Level II Final Site Plan Application
Lot 5 Industrial Way; CBL: 326-C-5
Application ID: 2015-085

On behalf of Deerfield 91 Industrial LLC, Sebago Technics, Inc. is pleased to submit this Level II Final Site Plan application for the proposed development located at 81 Industrial Way. The preliminary plans have been modified to address staff review comments. In addition, this letter and attached material are provided in response to the staff review comments as contained in your email dated June 18, 2015, peer review letter from Woodard & Curran dated June 10, 2015 and fire department review memorandum dated June 17, 2015.

FINAL SITE PLAN APPLICATION

81 Industrial Way

SHEET 2 OF 7

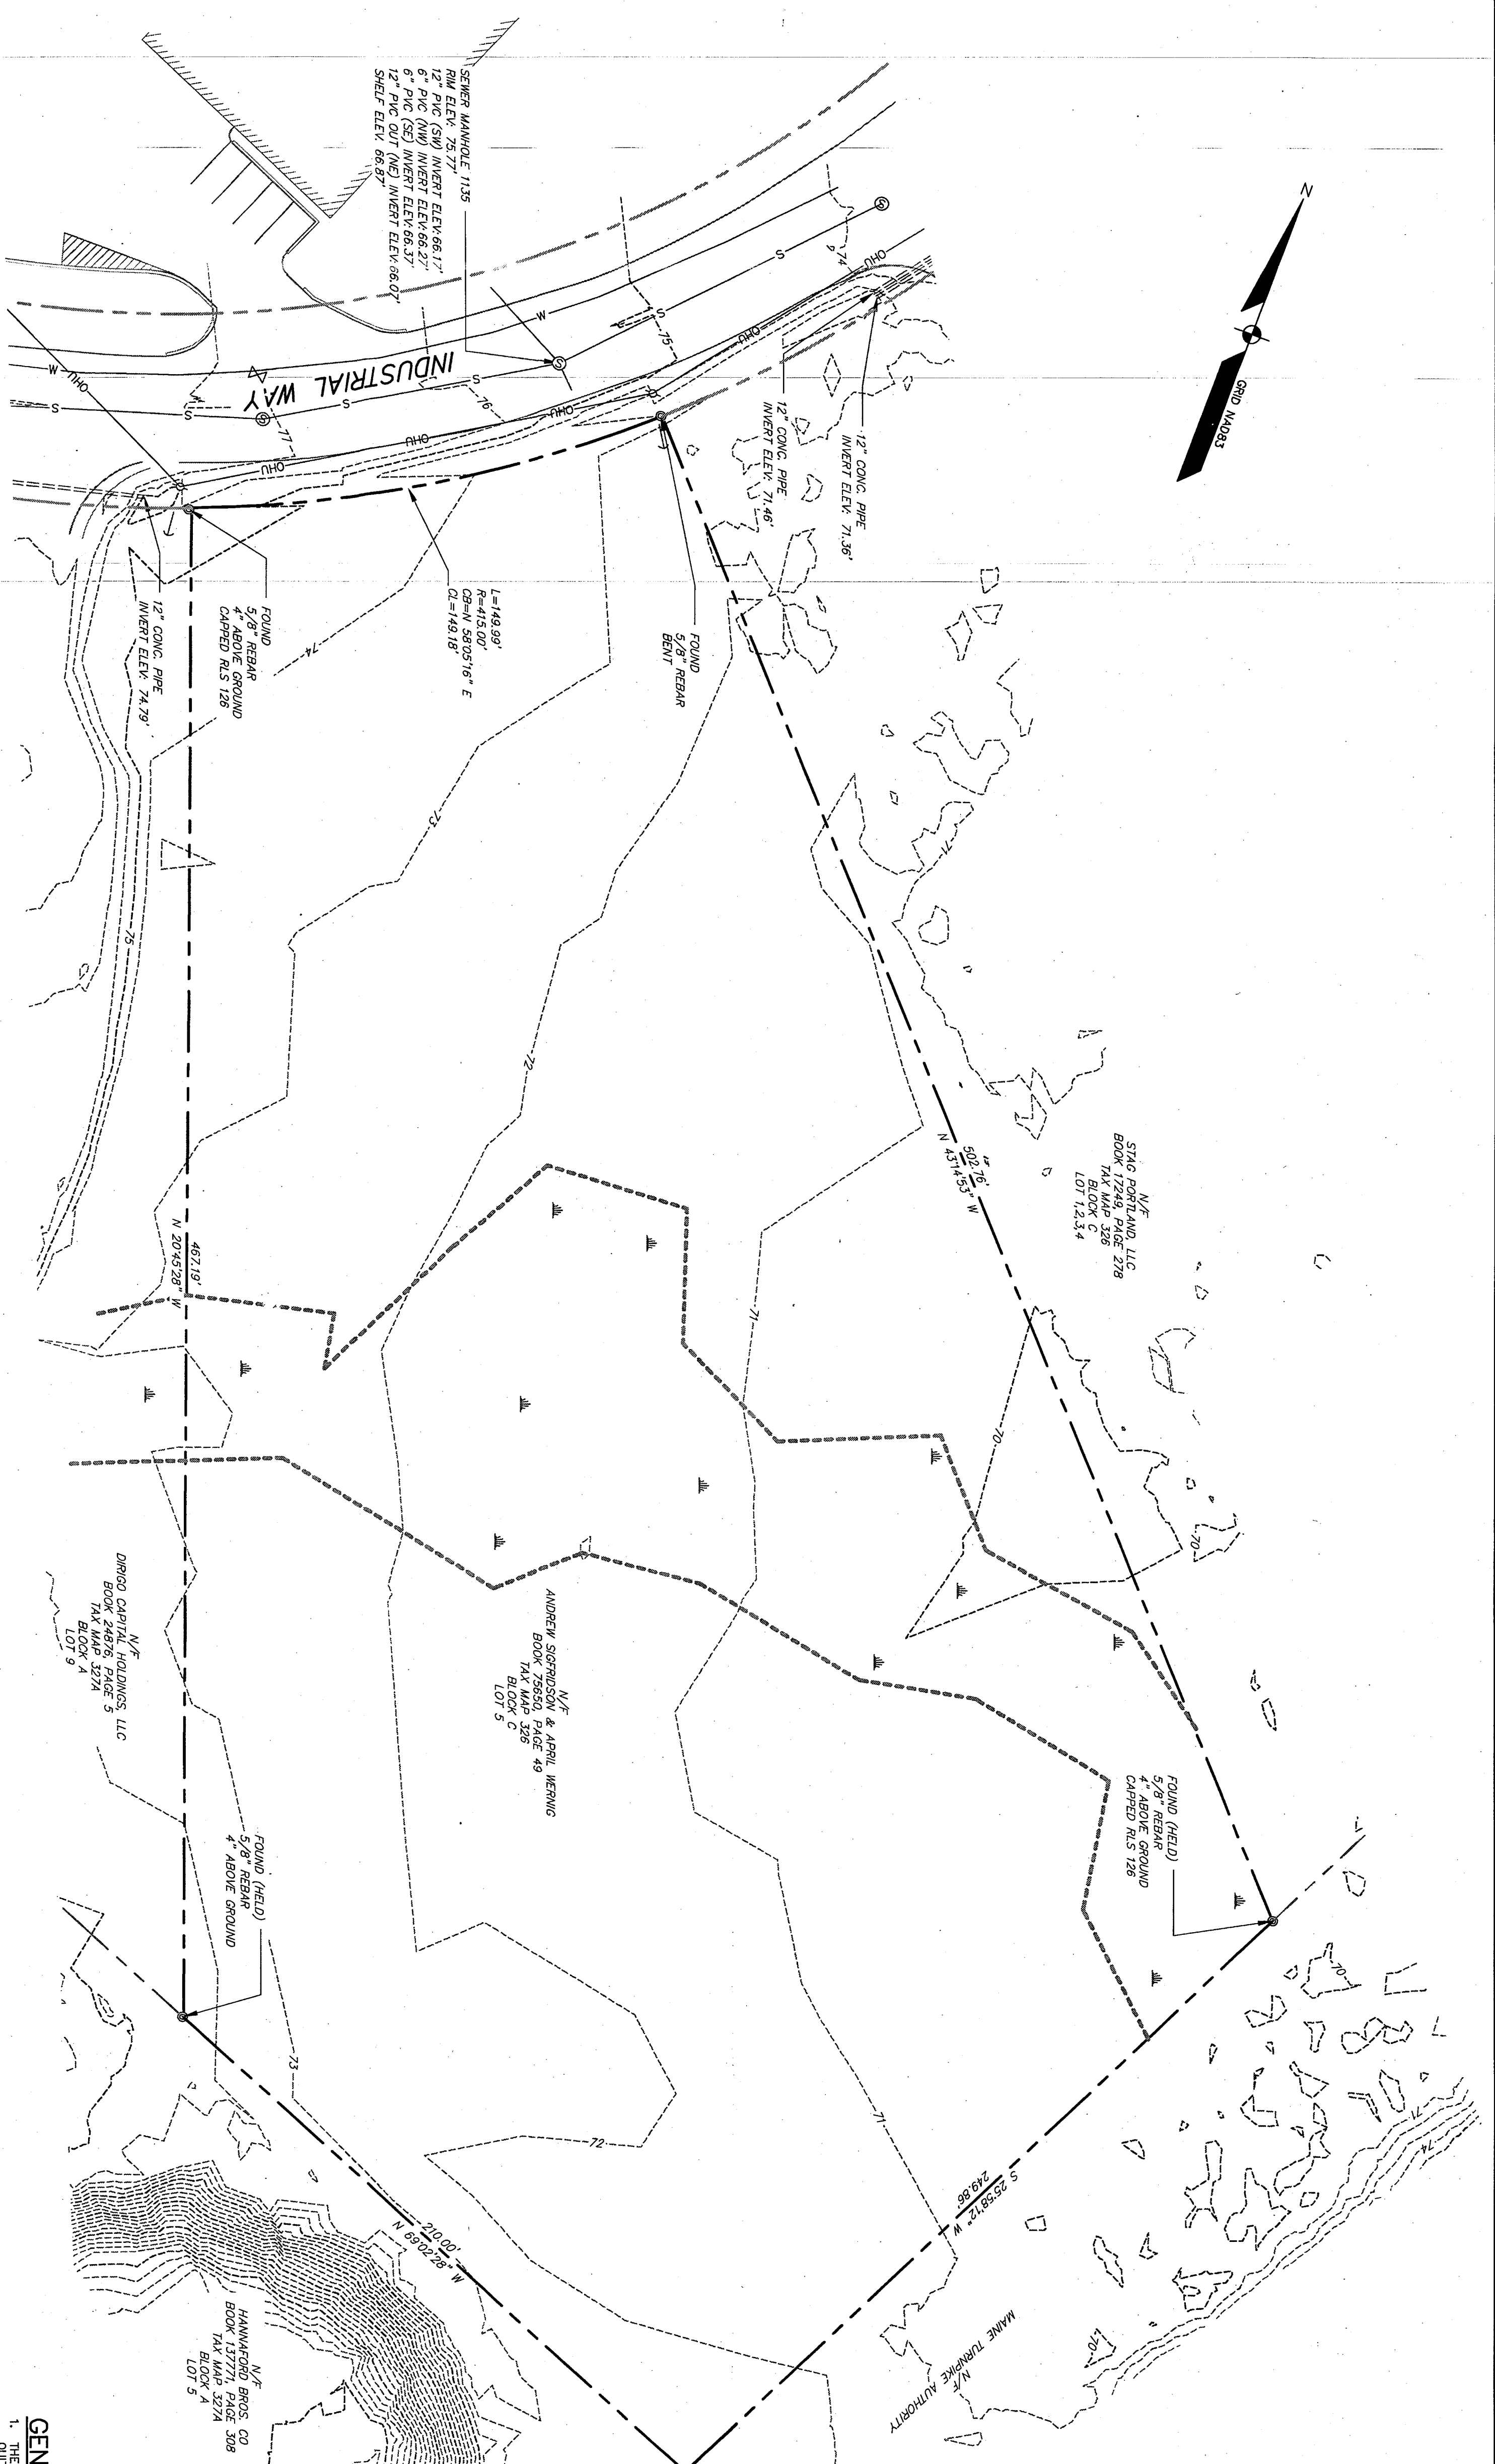
5. A stamped Boundary Survey is included in the plan set.
6. Locations for snow storage have been added to the plan.
7. Riprap protection locations and details have been added to the plans.
